# Objection to application 2026/NMA/91176/E

**Application:** 2026/NMA/91176/E

**Site:** Land to the rear of St Luke's, Bierley Marsh, East Bierley

**Proposal referred to:** Non-material amendment to previous permission 2024/93227 for variation of condition 2 (plans) on previous permission 2020/94345 (APP/Z4718/W/21/3289729) for erection of 5 dwellings, stated to include installation of PV panels to the row of four properties facing Bierley Marsh and the single-storey dwelling to the rear.

client name		Owens Developments Ltd	
project		New Dwellings - Land at St Lukes.	
drawing		House Type A : Terrace North and West Facing Elevations	
project number	19/157	plot date	24/11/20
		scale	1:100
drawing number	105	rev	B
		issue status	Planning Submission

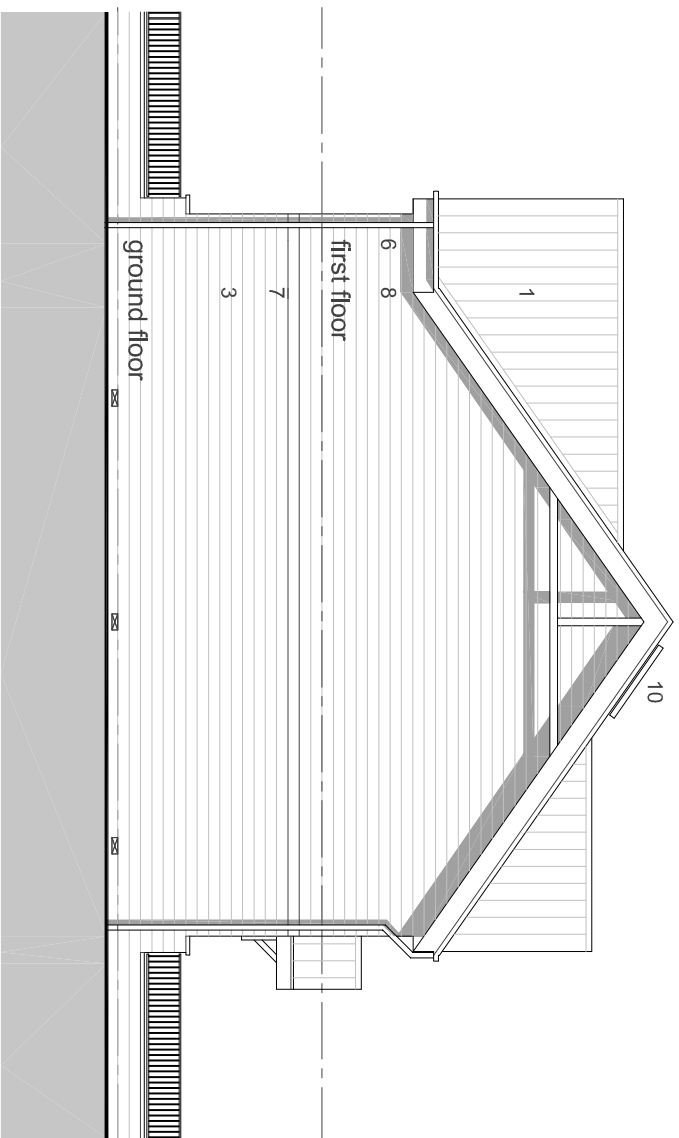
The amendment now seeks to alter the appearance of all five approved dwellings by installing PV panels, including on the row of four houses that directly face Bierley Marsh. On any ordinary planning view, that is a visible design change to the elevations and roofscape of the very buildings whose

appearance formed a central part of the Inspector's reasoning. A change of that nature in this location is not merely administrative, textual or incidental; it goes to external appearance, visual effect and the way the scheme presents itself in public views.

A non-material amendment procedure is not appropriate where the change would alter the appearance of the development in a way that may matter in planning terms. Here, the Inspector's decision shows that appearance, materials, roofscape, setting and the relationship with Bierley Marsh were central to the acceptability of the scheme. The proposal affects the public-facing terrace, in views from Bierley Marsh and in the setting of the conservation area.

The Council should also have regard to the Inspector's express statement that the terrace was acceptable because the materials proposed would be sympathetic to the local palette, and that the bungalow would include natural stone and a slate roof. Adding prominent PV arrays across those roofs changes the visual expression of the approved materials and roof planes. Whether one supports renewable energy in principle is not the point; the issue is that this is plainly a design alteration with potential heritage and townscape consequences.

drawing  
House Type B : North and East Elevations

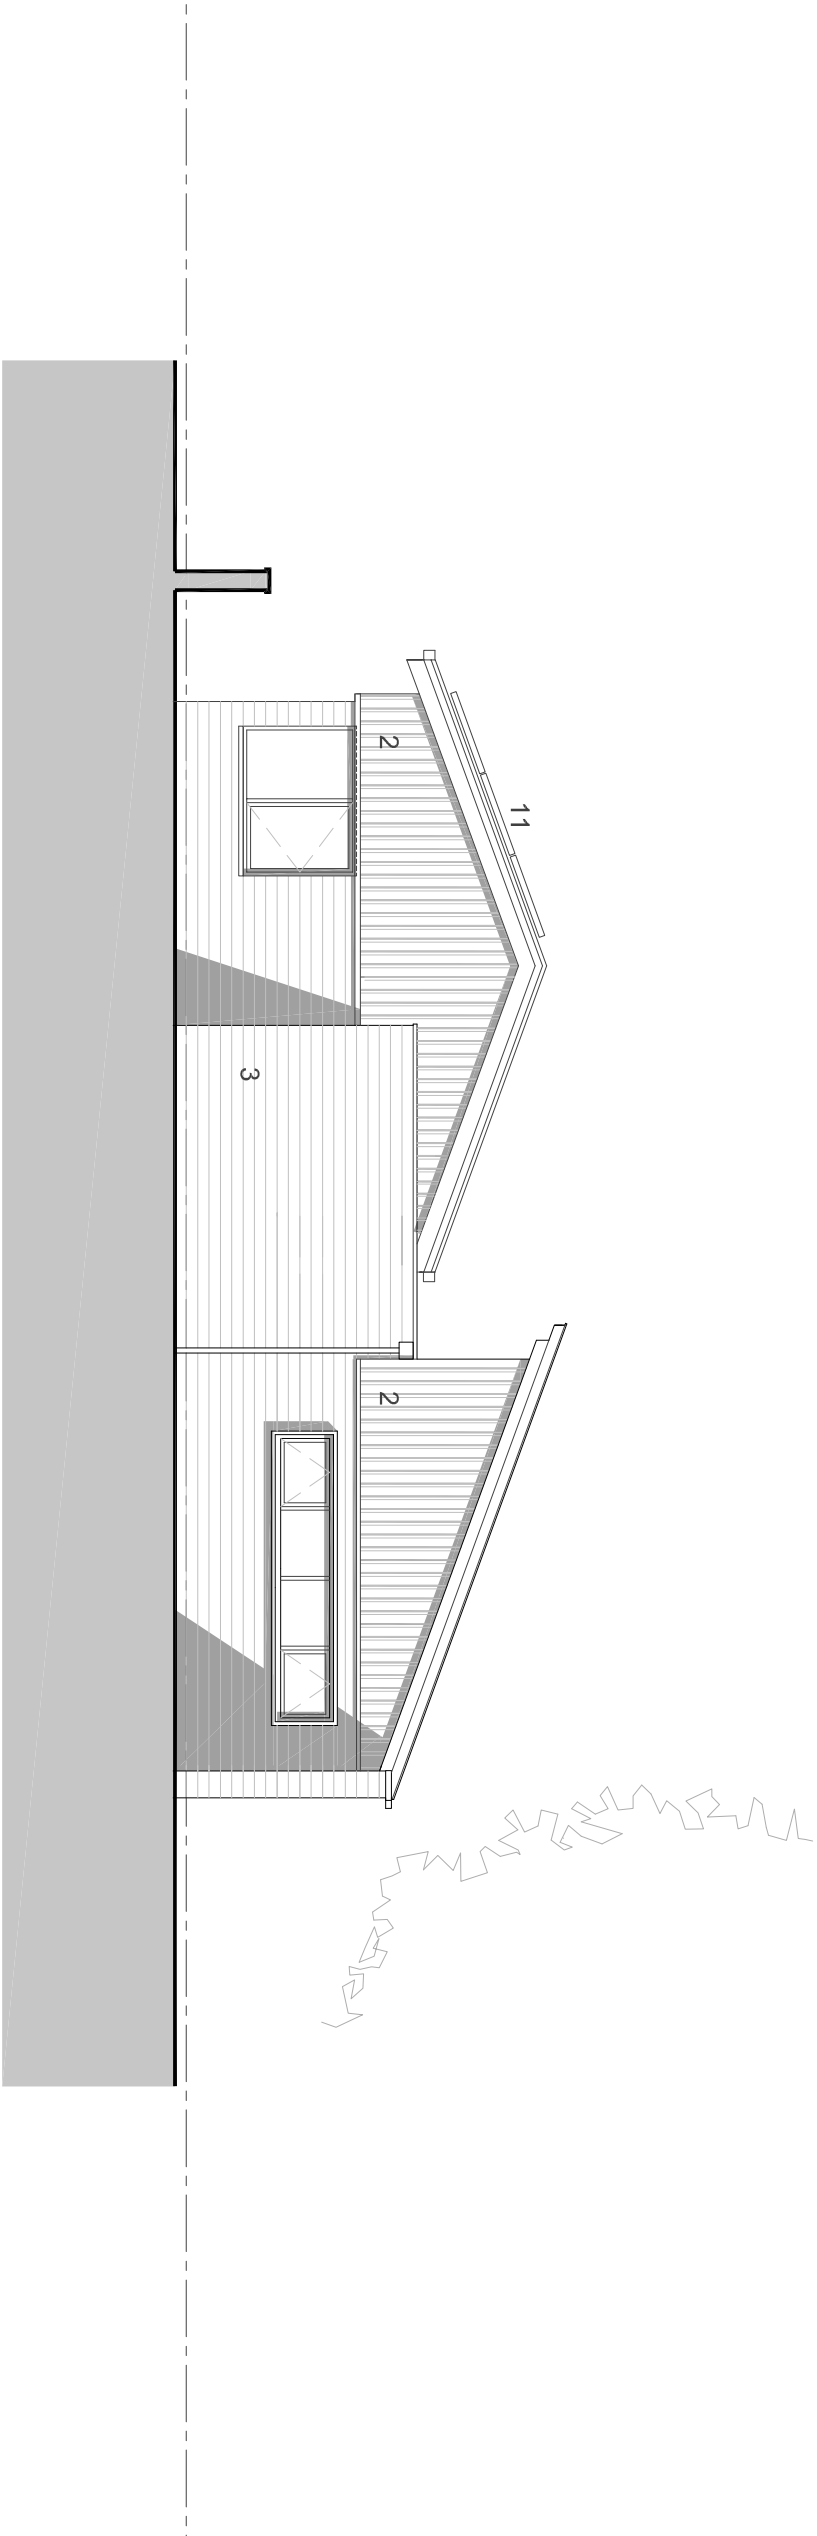
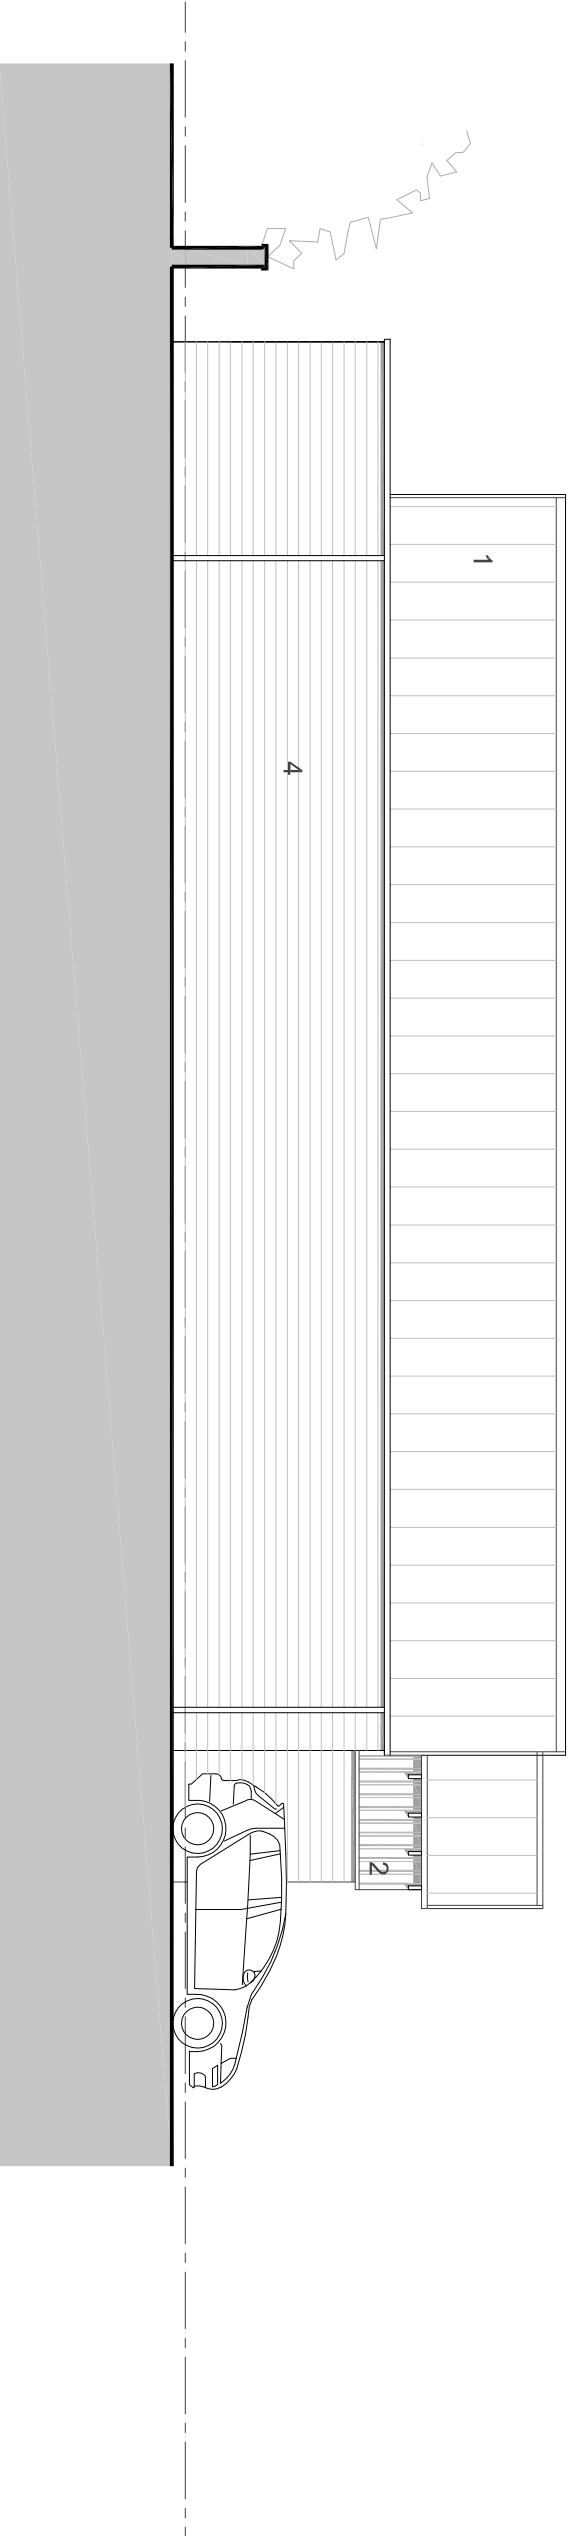
The proposal is also site-wide in effect, covering the four front dwellings and the rear bungalow. That cumulative change reinforces why it cannot properly be characterised as trivial or non-material. If the developer wishes to revise the approved design in that way, the proper course is a full application or at least a route that allows full assessment of design, heritage and amenity impacts rather than a non-material amendment.
